EPC STORMWATER REVIEW COMMENTS
IN ORANGE BOXES WITH BLACK TEXT

ESTATES AT CATHEDRAL PINES
WINSLOW DRIVE
BLACK FOREST, CO 80908
AMENDED DEVELOPMENT PLAN

SHEET TITLE:
LANDSCAPE PLAN

FILE NO.
PUDSP2210

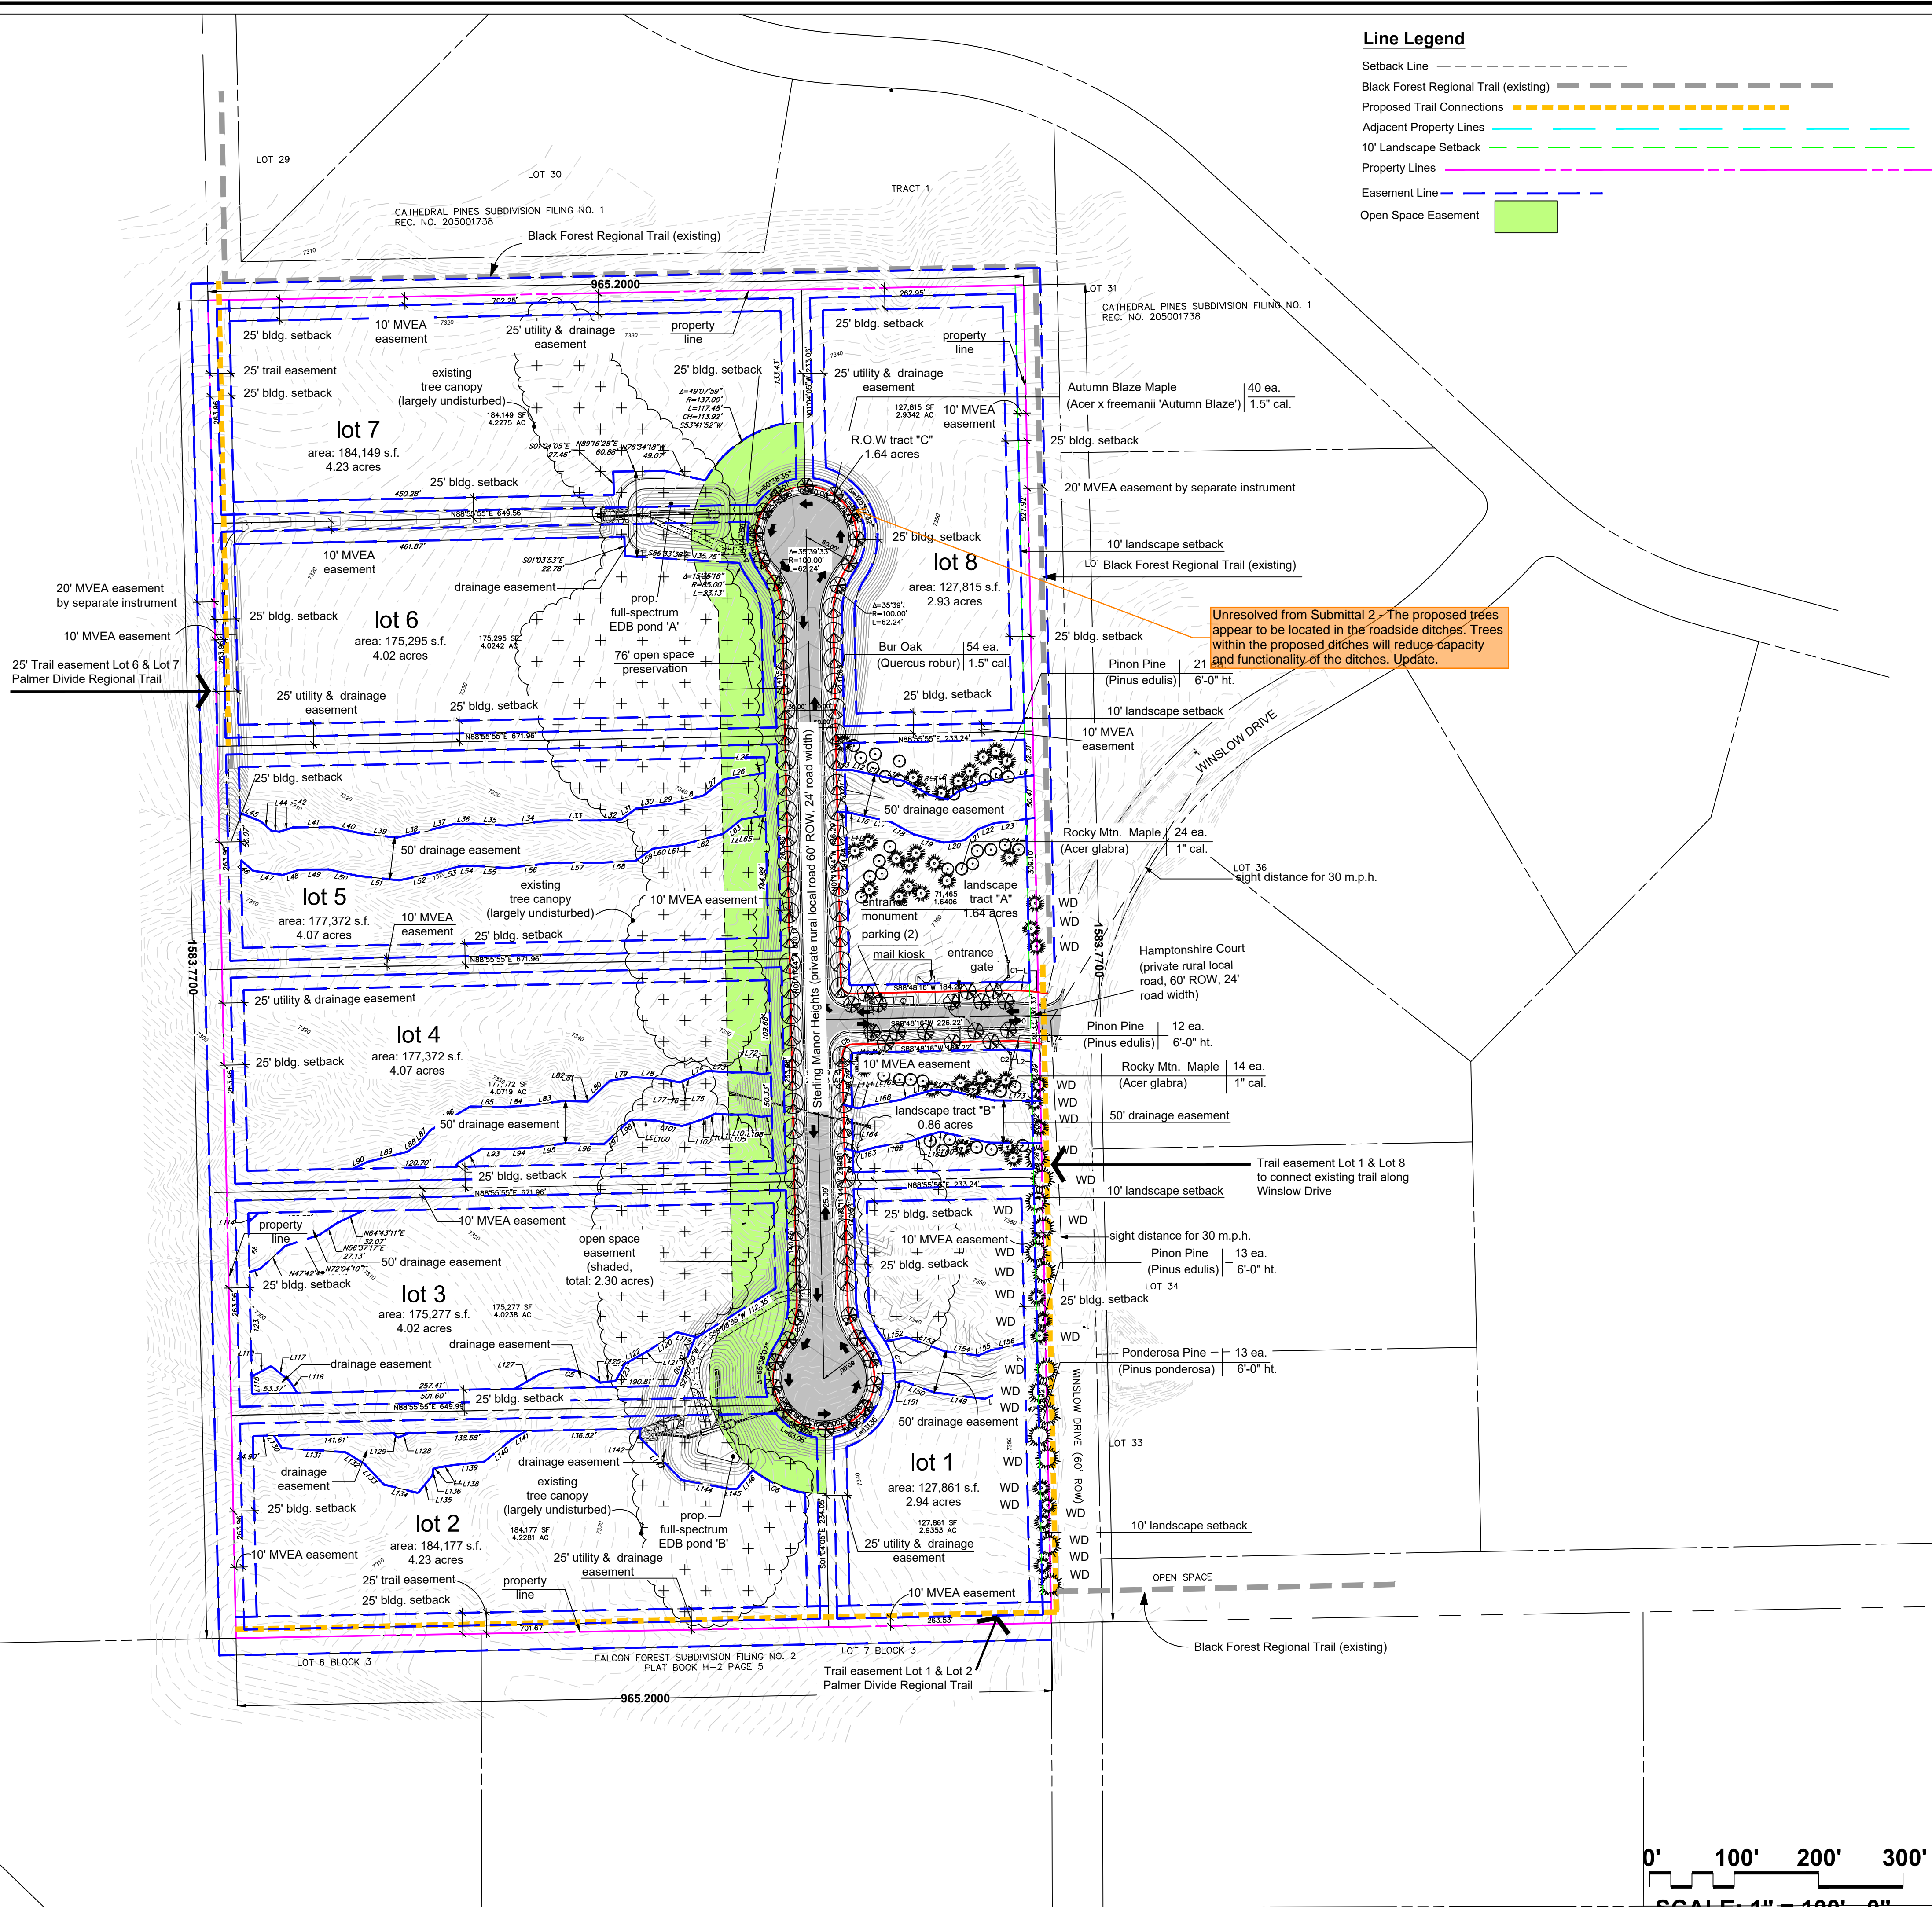
The proposed trees appear to be located in the roadside ditches. Trees within the proposed ditches will reduce capacity and functionality of the ditches. Update.

recommend tree location be reviewed against planned drainage and utility easement along the sides of the private road.

Refine pond easement boundary line with allowance for driveway. Tree spacing may need adjustment to accommodate driveway entrances along the private road
